15 March 2024

**SECTION 73 APPLICATION TO VARY CONDITION 1 RELATED TO APPROVED DRAWINGS TO PLANNING CONSENT 23/00863/FUL.
AT BOB'S FARM, VYNE ROAD, SHERBORNE ST JOHN, HAMPSHIRE, RG24 9HX.
FOR THE ERECTION OF 9 DWELLINGS AND ASSOCIATED LANDSCAPING, ACCESS AND CAR PARKING FOLLOWING THE DEMOLITION OF EXISTING AGRICULTURAL AND B8, STORAGE AND DISTRIBUTION USE BUILDINGS AND HARDSTANDING.**

JOB NO.: 8160 DRAWING NO.: D03 REV: C

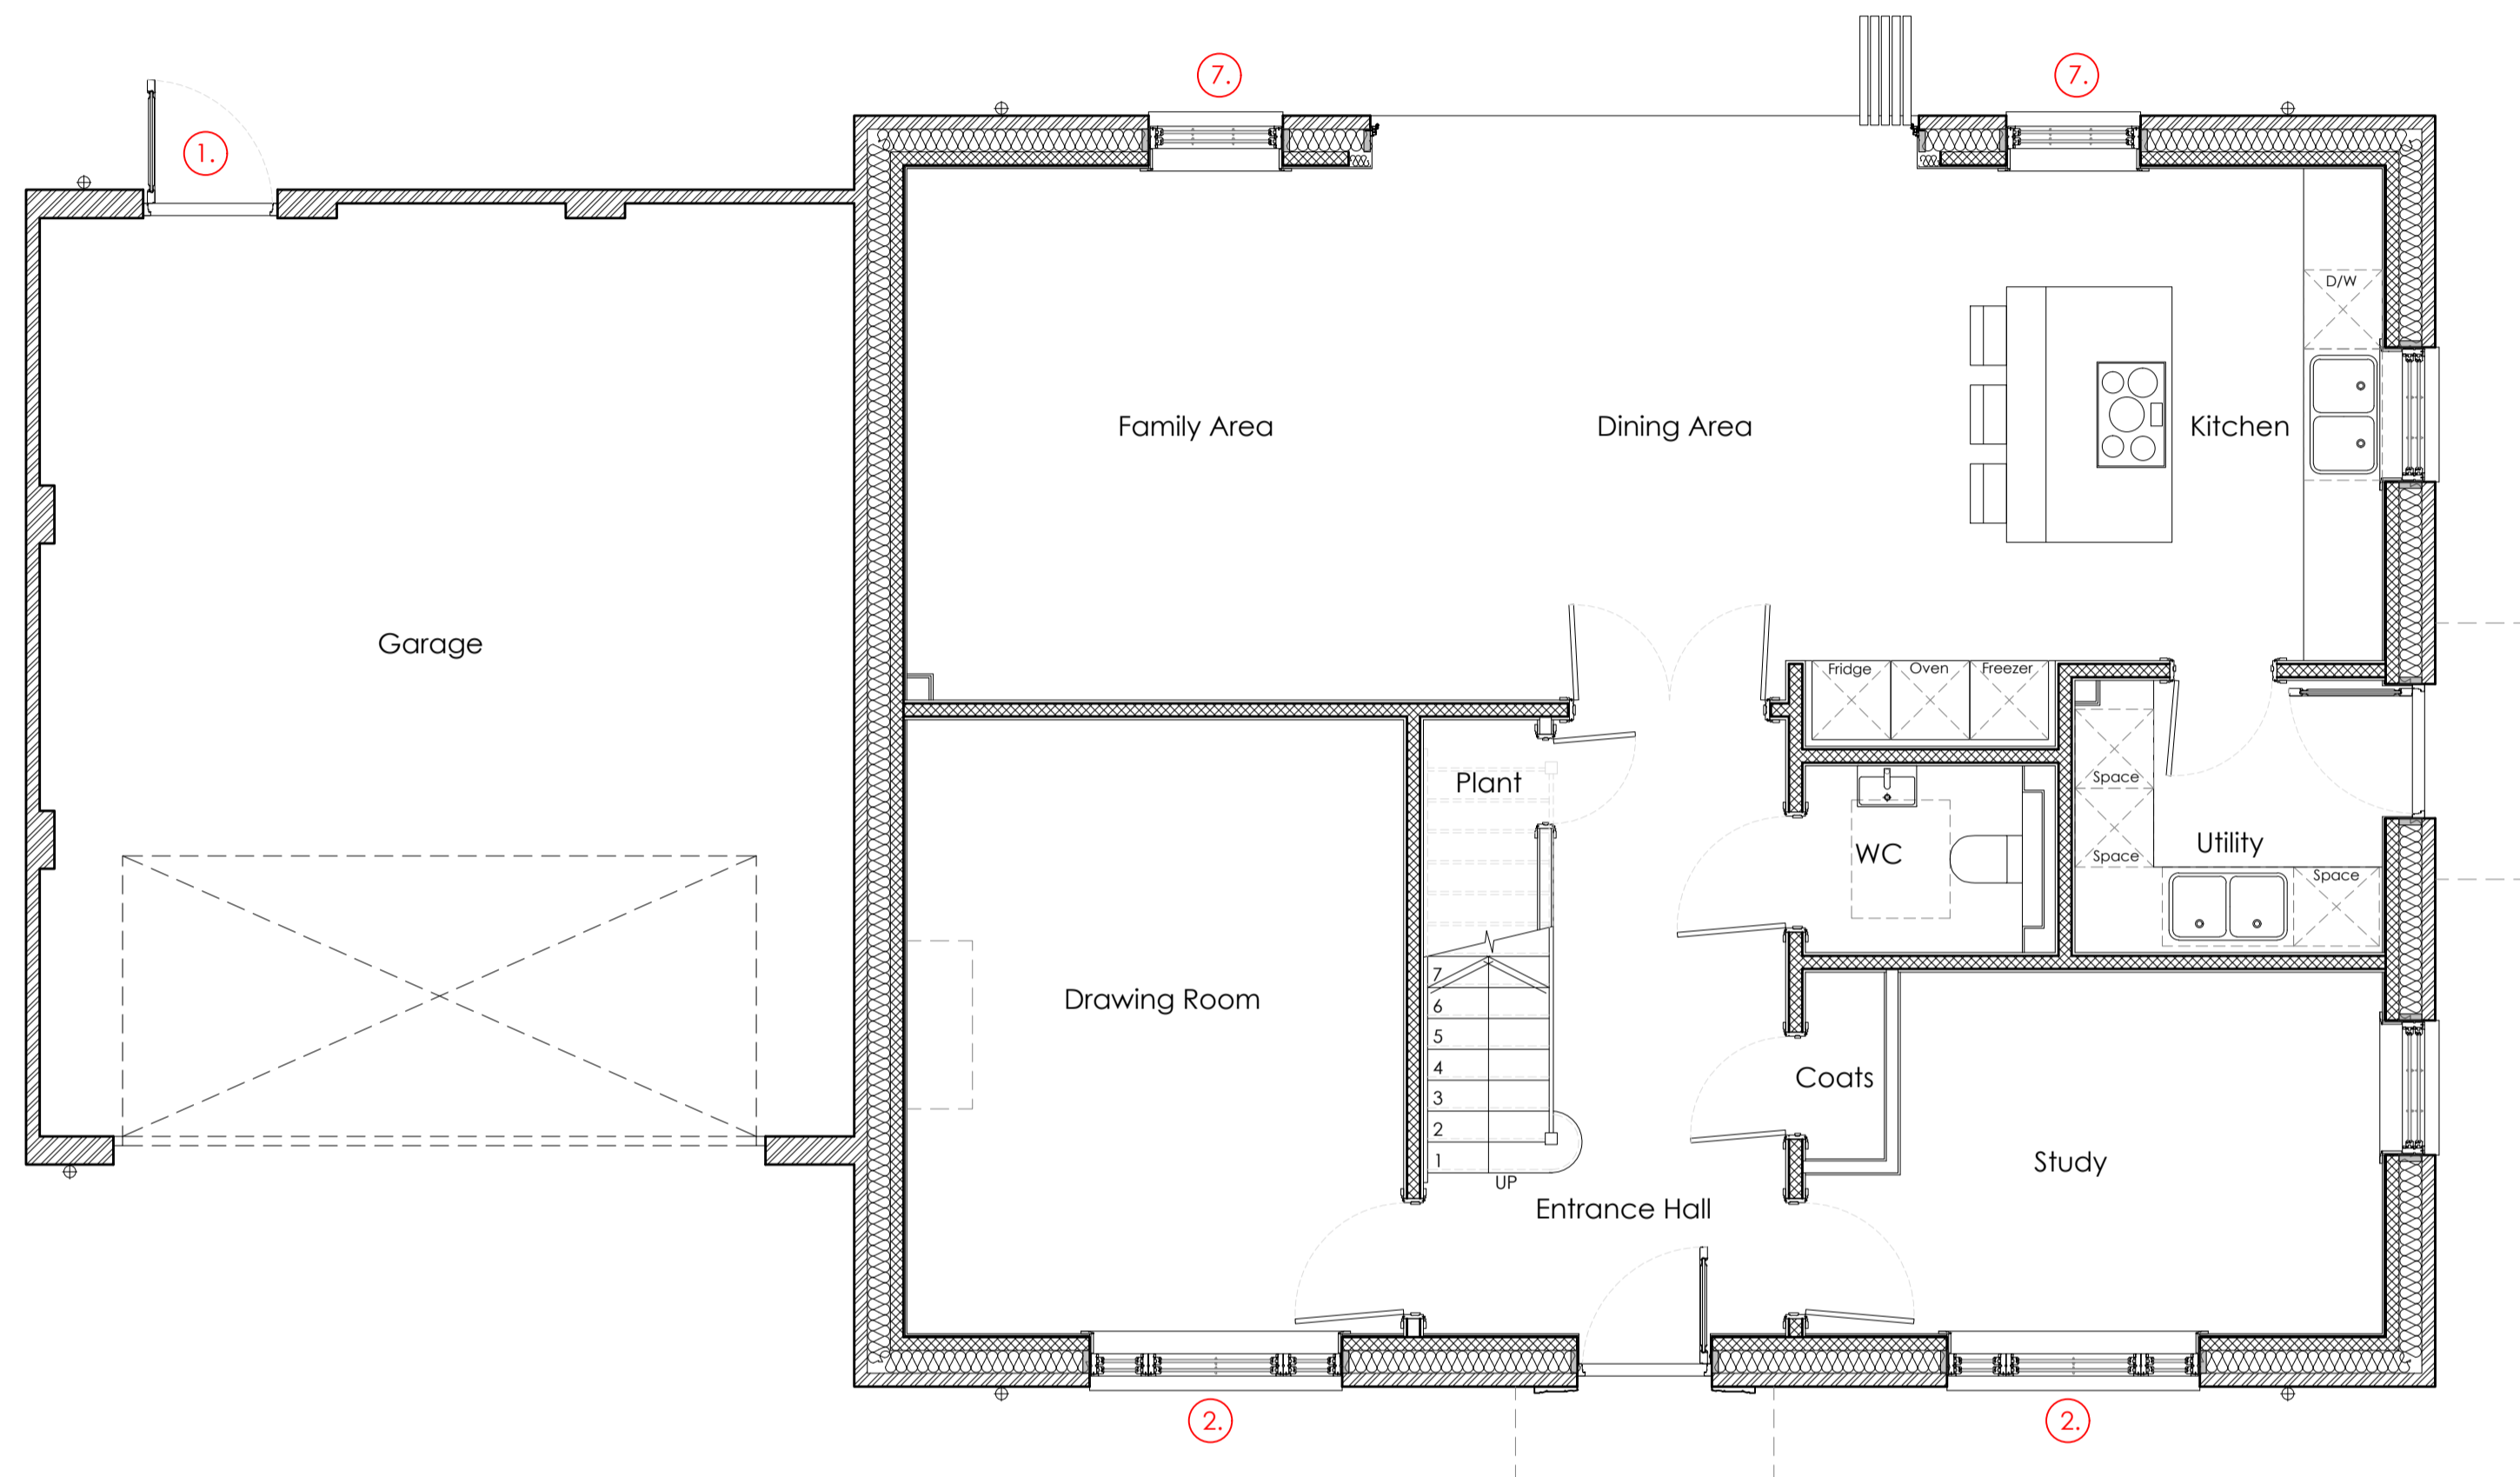
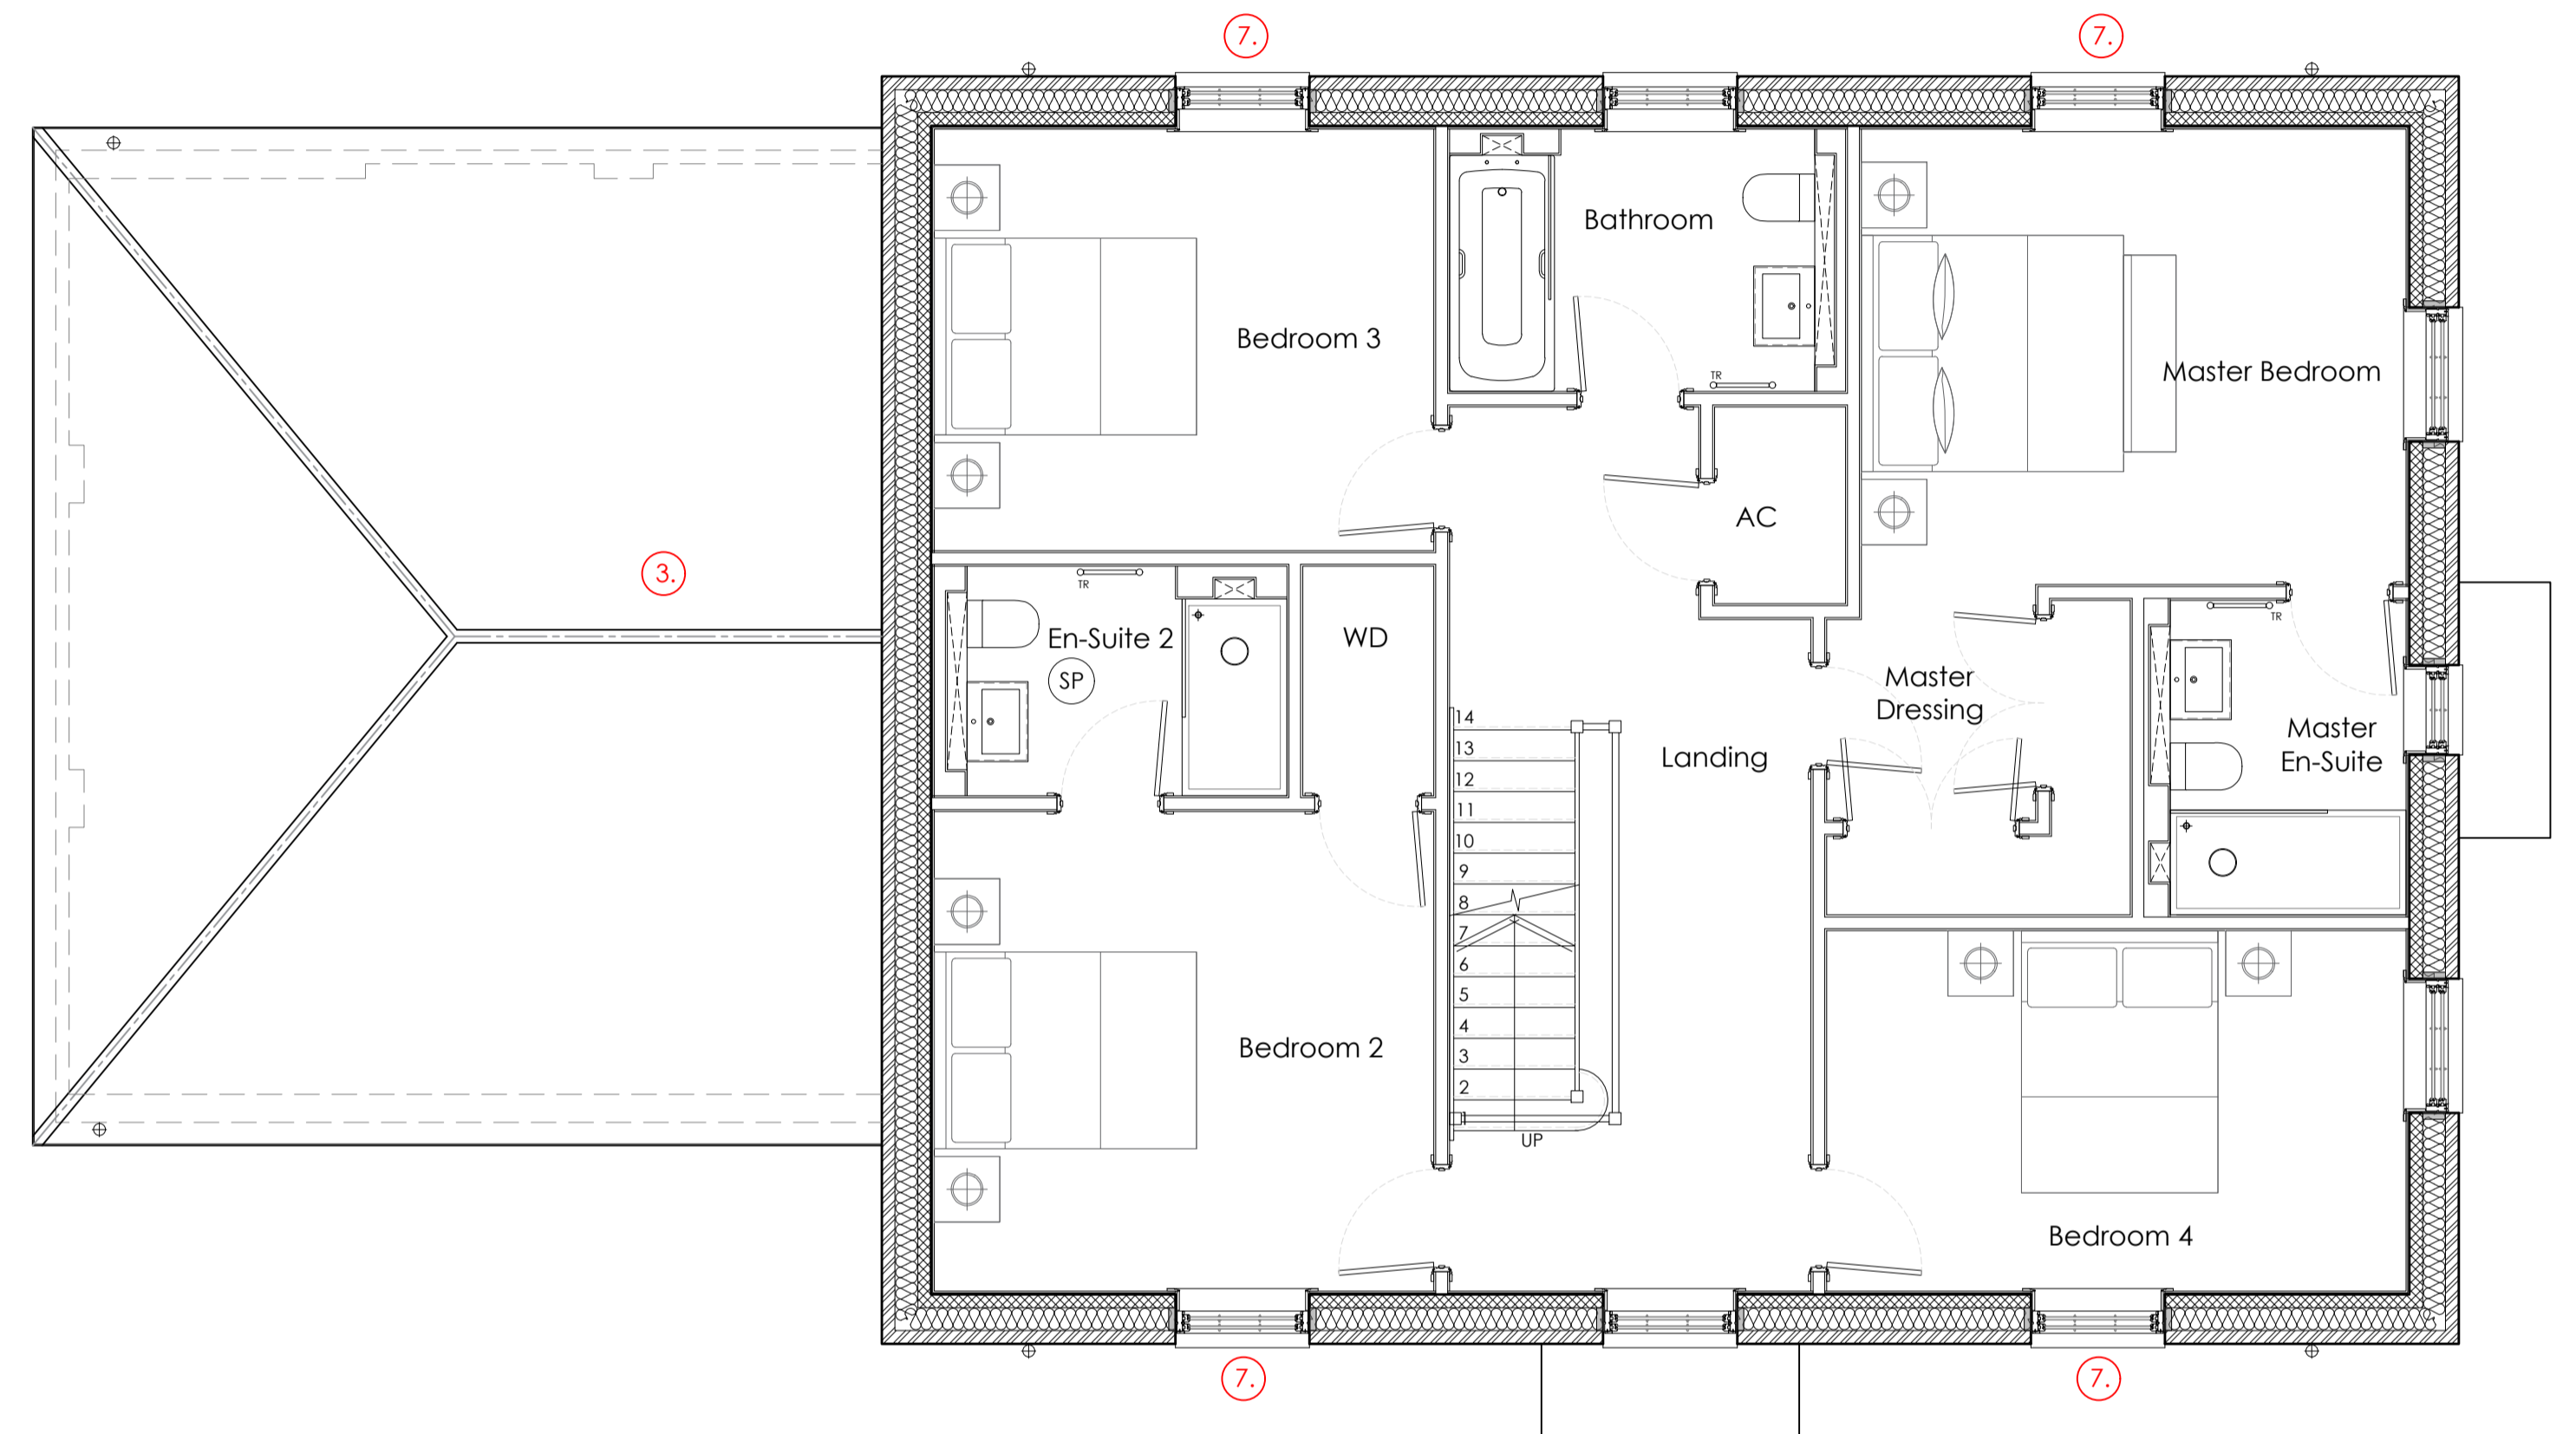
- Plot 1 – amend roof type to omit flat roof; fenestration changes; amend chimney position and reduce height; and change clay tiles with slate.
- Plots 2 & 3 – fenestration changes including additional window and sunpipe; remove flue; and change slate tile to clay tiles.
